Ribble Valley Borough Council
Planning Section
Council Offices
Church Walk
Clitheroe
BB7 2RA

Planning Application No: 3/2024/0461

Proposal: Proposed change of use of offices (class E) to a children's care home (class C2 Residential Institutions) including installation of patio doors, composite decking and steps to rear elevation and addition of a 1.8m high timber boundary fence between Dixon House and The Homestead.

Location: Dixon House, Whalley Road, Wilpshire BB1 9LL

**PROPOSED SITE PLAN**  
Scale 1:200

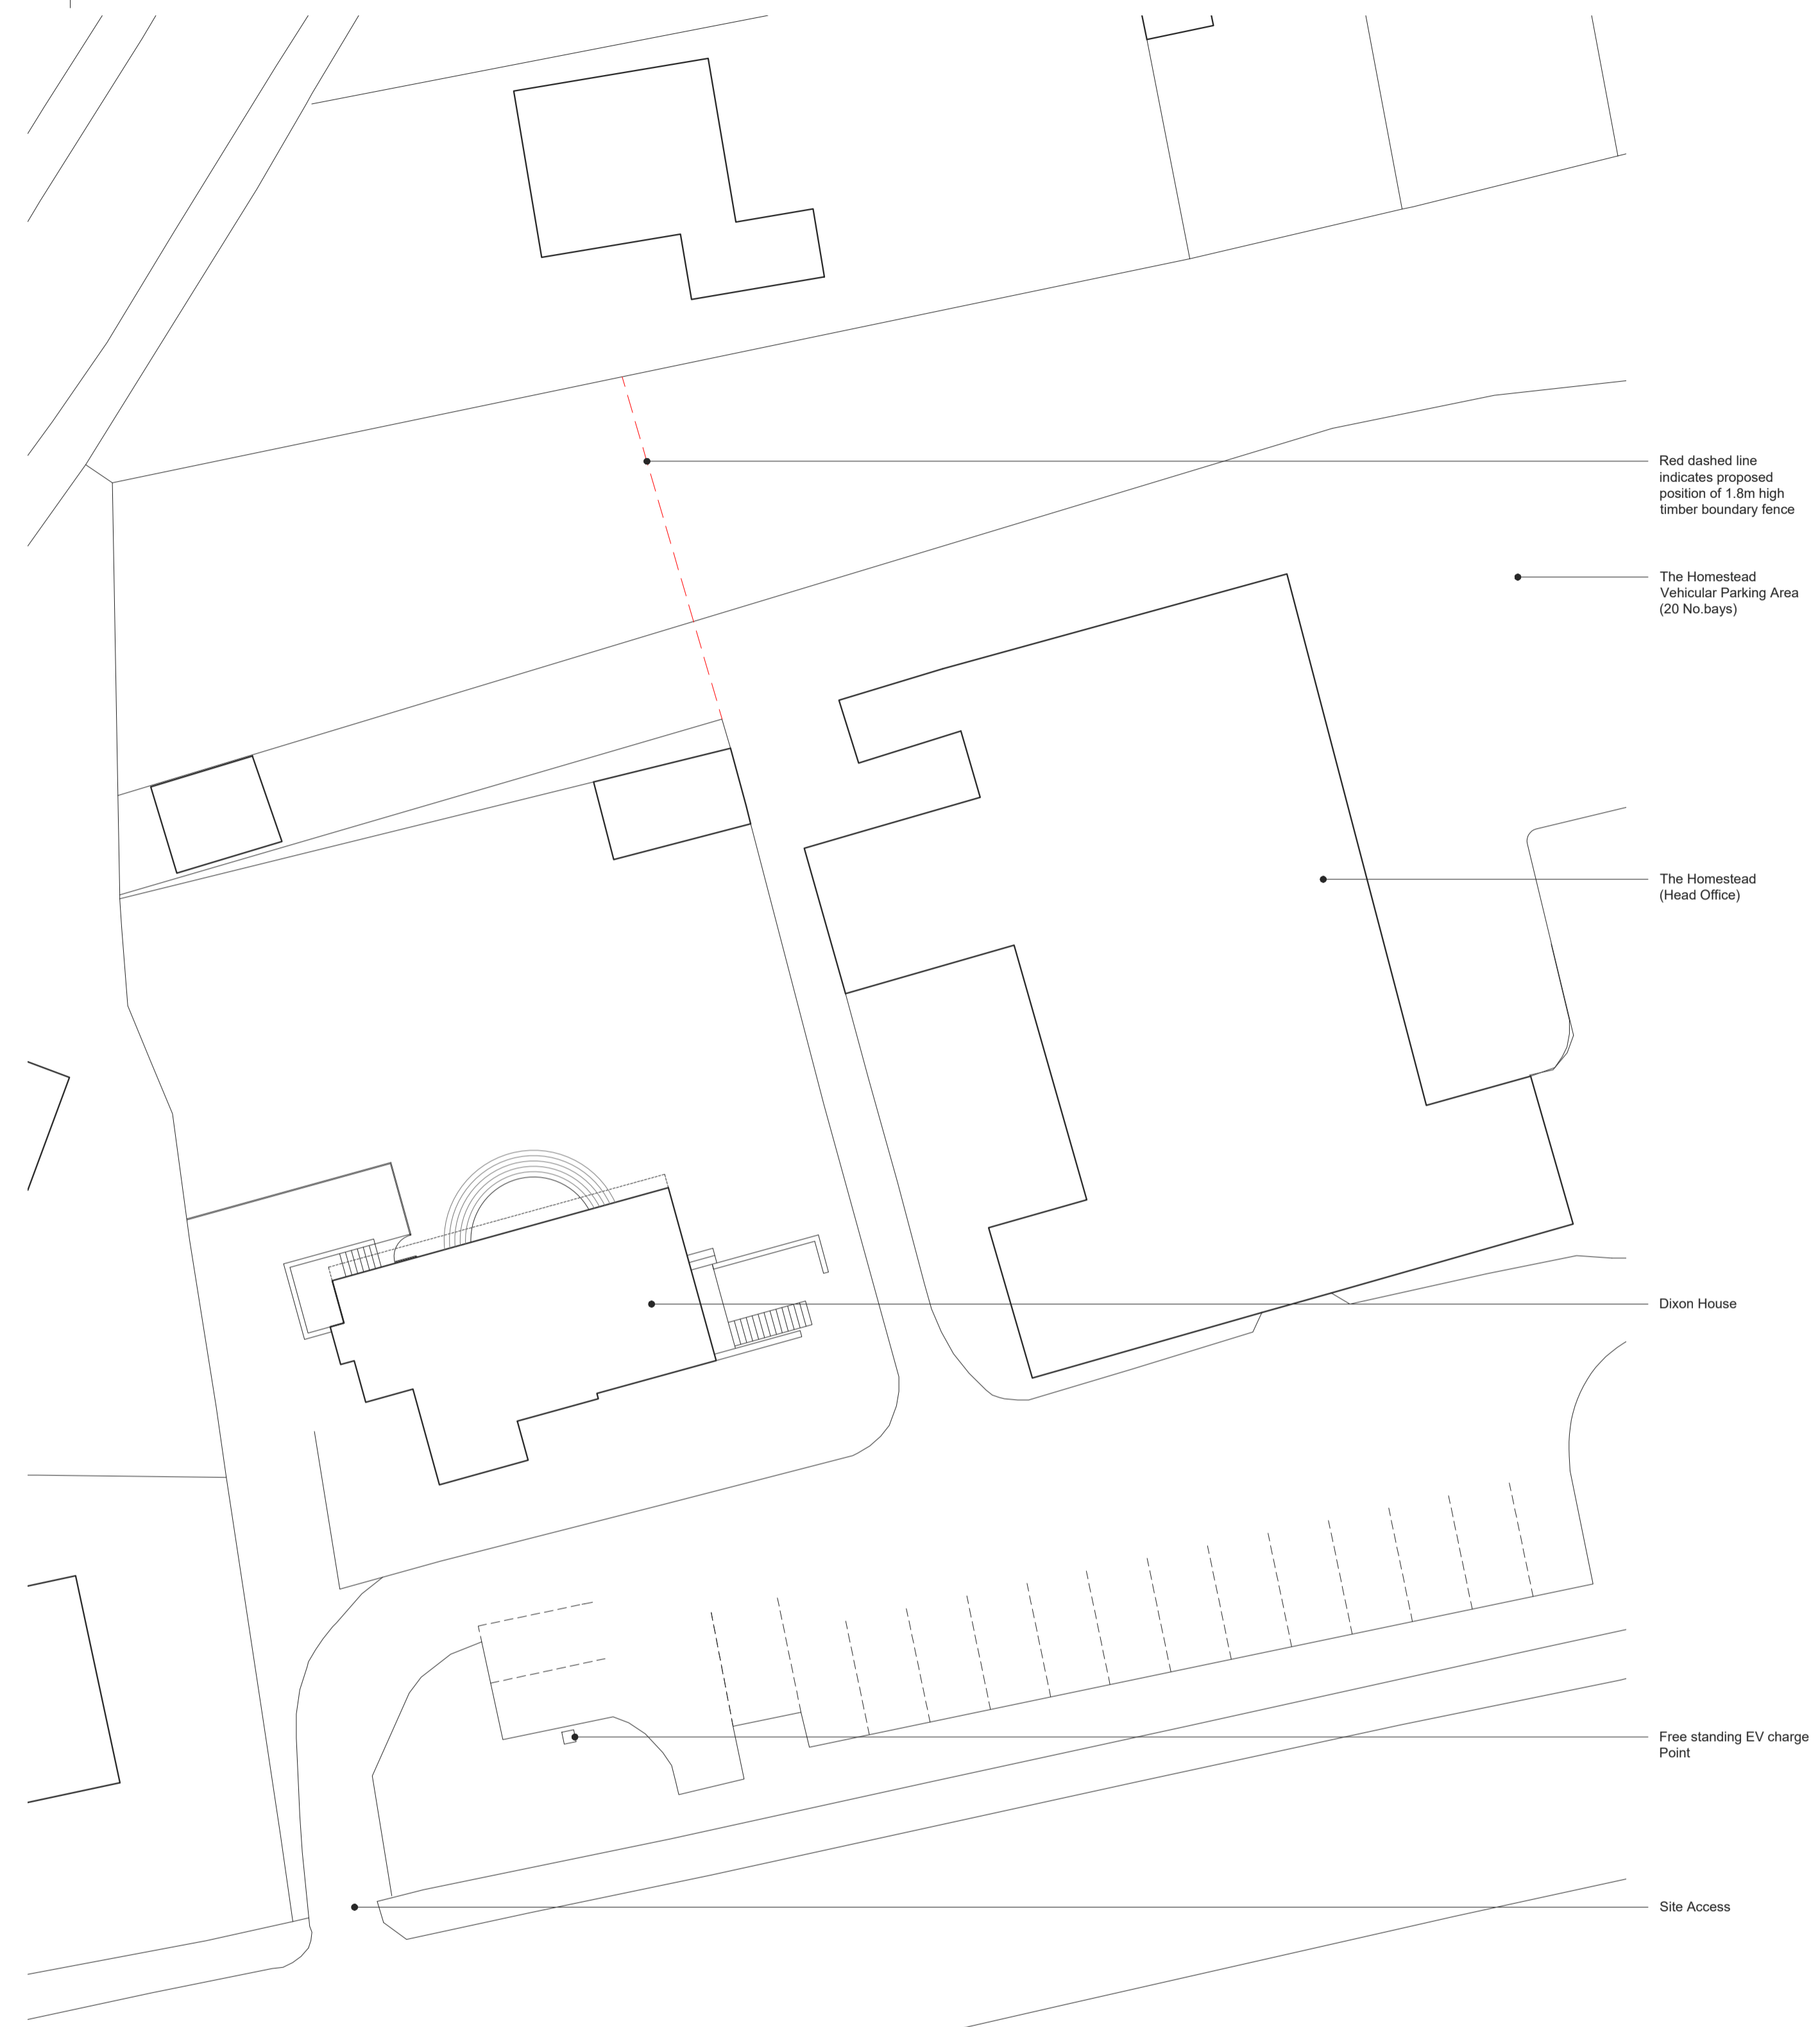
It is proposed to retain four of the existing car parking spaces at the front of the property which the highway authority considers to be an adequate level of off-road parking given the details of site staffing levels and operation submitted.

An electric vehicle charging point is shown on the Proposed Site Plan (Drawing 2327-04). This shall be fitted in line with the Dept for Transport's guidance regarding Electric Vehicle Charging in Residential and Non-residential Buildings, which states that charge points must have a minimum power rating output of 7kW and be fitted with a universal socket that can charge all types of electric vehicles.

1. Prior to first occupation of the approved development the parking and manoeuvring areas shown on the approved plans shall be made available and thereafter always remain available for the parking and manoeuvring of vehicles associated with the development and shall be kept free from obstructions in perpetuity. Reason: In the interest of highway safety to ensure that satisfactory levels of parking and manoeuvring are provided within the site.
2. Prior to first use of the approved development an electric vehicle charging point shall be installed in accordance with the approved plans. Charge points must have a minimum power rating output of 7kW and be fitted with a universal socket that can charge all types of electric vehicle currently available. Reason: To ensure that the development supports sustainable forms of transport.
